# FOREST HEIGHTS ESTATES CONSTRUCTION DRAWINGS

## FOR FOREST HEIGHTS CIRCLE COUNTY OF EL PASO, STATE OF COLORADO

FOREST HEIGHTS CIRCLE  
CONSTRUCTION DRAWINGS  
TITLE SHEET

**TYPICAL PRIVATE RURAL ROADWAY SECTION**  
RURAL GRAVEL LOCAL ROADWAY  
WITH A DESIGN AND POSTED SPEED OF 20 MPH

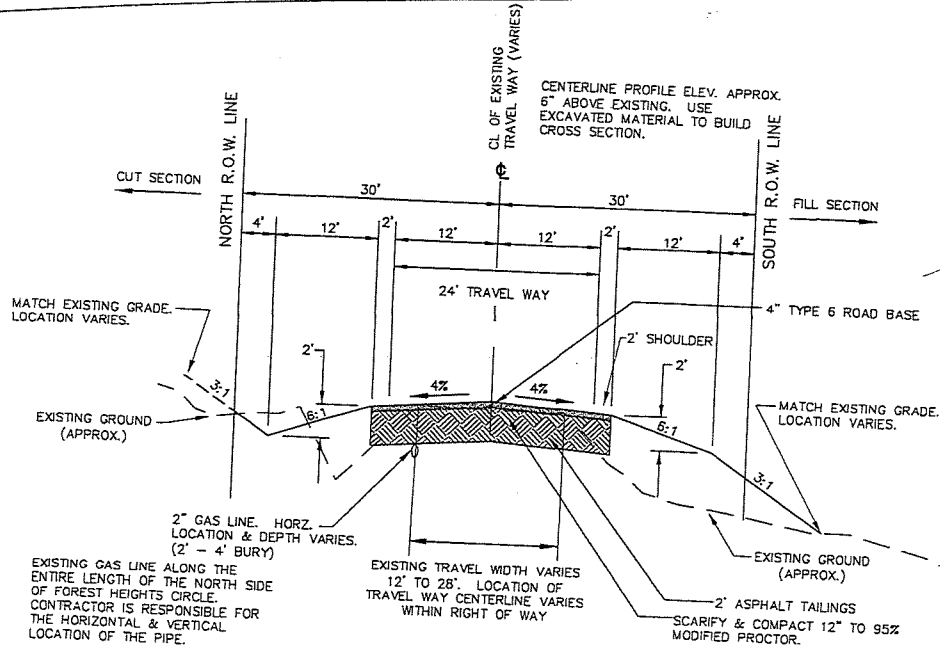
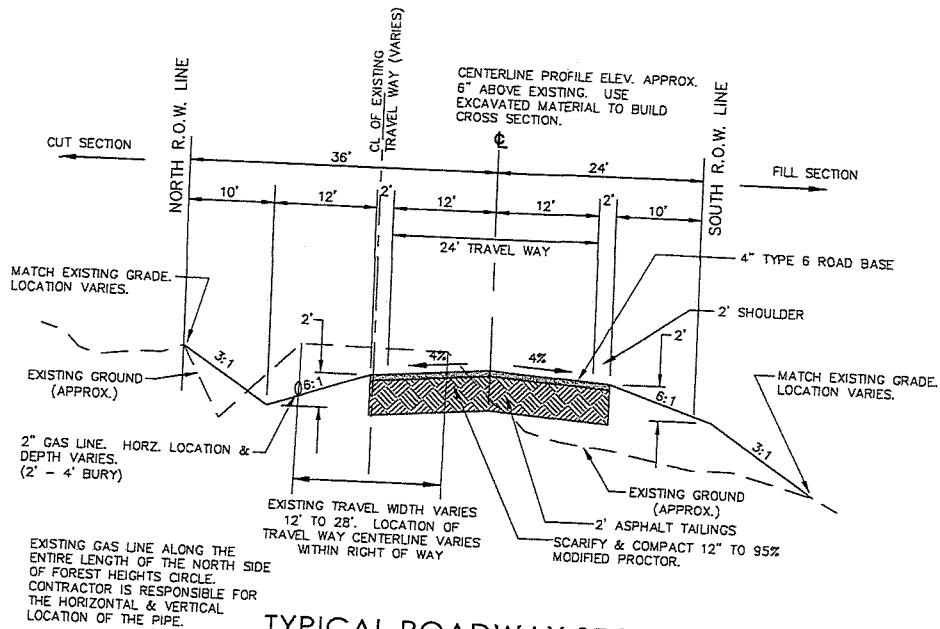
update detail and plans per comments provided on the deviation request as a 24 ft. wide road would not be supported.
